Recommendation Report for Planning Permission for Works or Extension to a Dwelling

REF NO: WA/85/19/HH

LOCATION: 20 Henty Close
Walberton
BN18 0PW

PROPOSAL: Proposed loft conversion, new dormer and alterations to front entrance porch (The application may affect the setting of a Listed Building)

Proposed Elevations

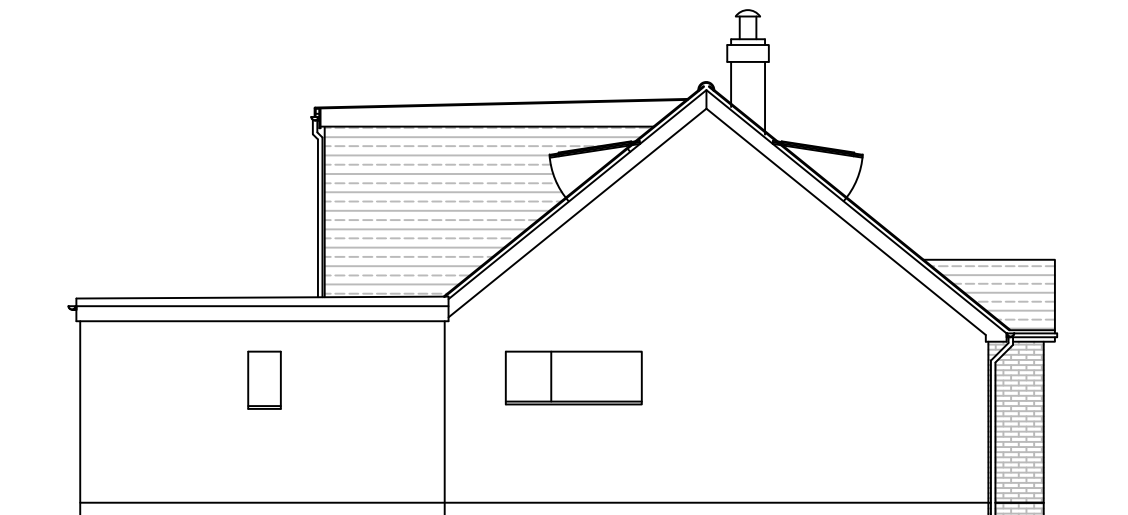
The proposed alterations, including the change of the roof design will be visible from the public realm. However, these are not considered to be harmful to the character and appearance of the host dwelling, or it's wider locality. This is due to the minor scale of the alterations, and the siting of the host dwelling allowing for a reduced impact on the street scene, or the wider locality of the area. Resultant of its modest scale, the proposed porch is considered to appear subservient to, and well integrated with, the host dwelling.

The proposed rear dormer is considered to an acceptable addition to the host dwelling, this is due to its siting allow there to be no views of the dormer from the public realm. Additionally, due to its scale, and design, it is considered to appear subservient to the host dwelling, as it spans just over half, of the rear roof slope of the host dwelling.

The proposed development, due to its siting and scale is not considered to result in any unacceptably harmful impact upon the residential amenities of nearby dwellings. This is due to the siting of the proposed development being sited an acceptable distance from neighbouring dwellings in order to prevent any significantly harmful overshadowing or overbearing impact on the occupiers of said dwellings. The proposed rear dormer is not considered to result in any significantly harmful overlooking of adjacent dwellings, due to the fact that the views from the dormer face East, and therefore any views of neighbouring dwellings would be oblique and indirect.
